Consultee Comments for Planning Application 21/00669/FUH

Application Number: 21/00669/FUH

Proposal: Erection of perimeter metal railings and electric sliding gates.

Name: _ Arboricultural Officer - LDC

PROPOSED SECURITY FENCING & GATES TO PROPERTY FRONTAGE at "FAIRWAYS", DRAYTON LANE, DRAYTON BASSETT, STAFFS B78 3TS (SCALE 1: 100)

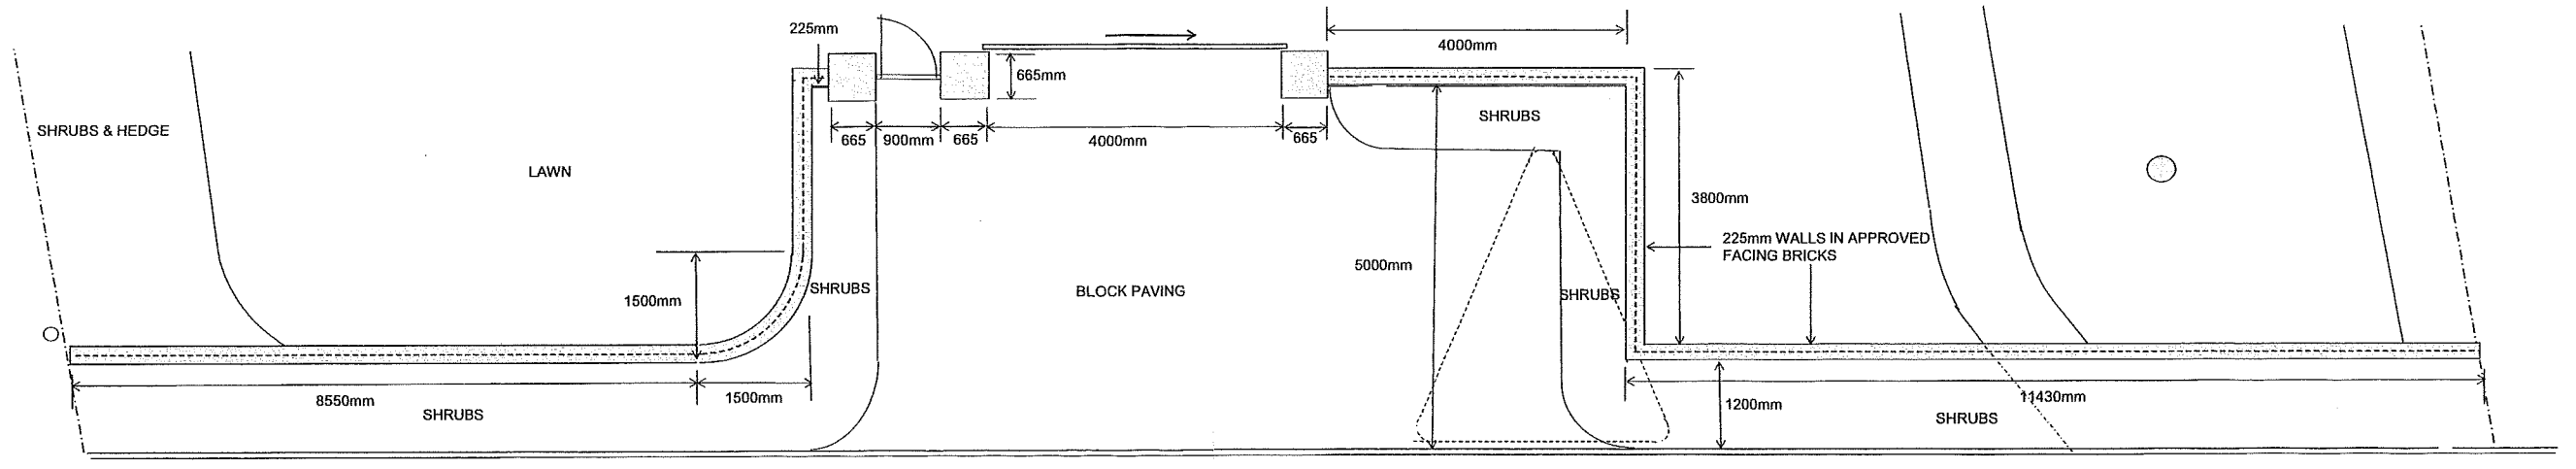
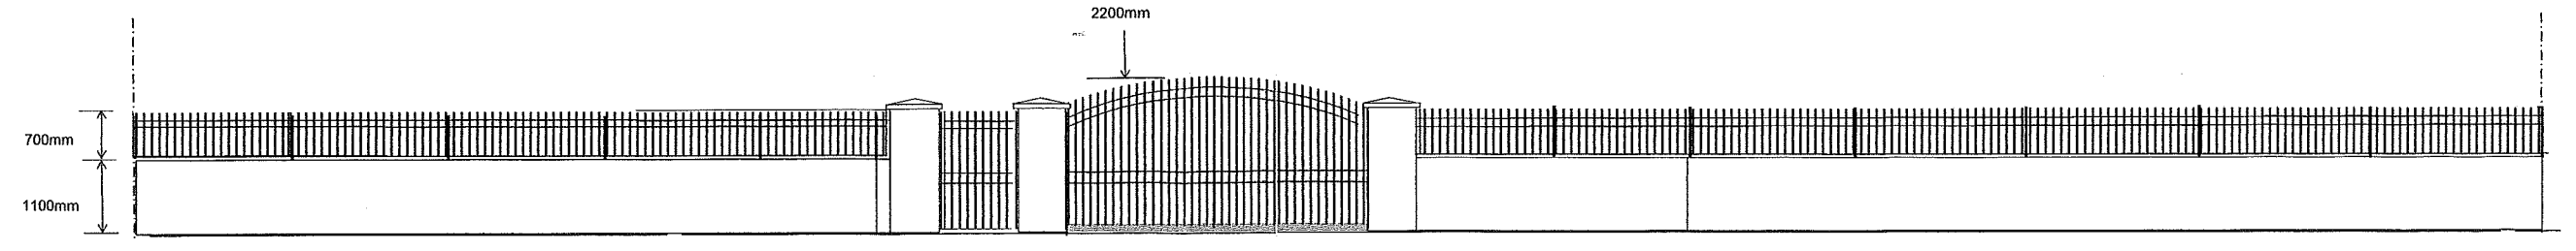
Whilst the site is not within any designated conservation area there are currently a number of TPO'd trees on site, and it does appear that there are large trees affected some of which may be on third party land.

In addition the proposal has an impact on the street scene which is currently open plan and verdant.

As such we cannot support this proposal and ask that if the applicant wishes to pursue this that a tree report to BS5837 is provided and this should include a constraints map and tree protection plan and a proposed form of landscaping to soften the impact and this may require the wall to be set farther back from the highway curtilage.
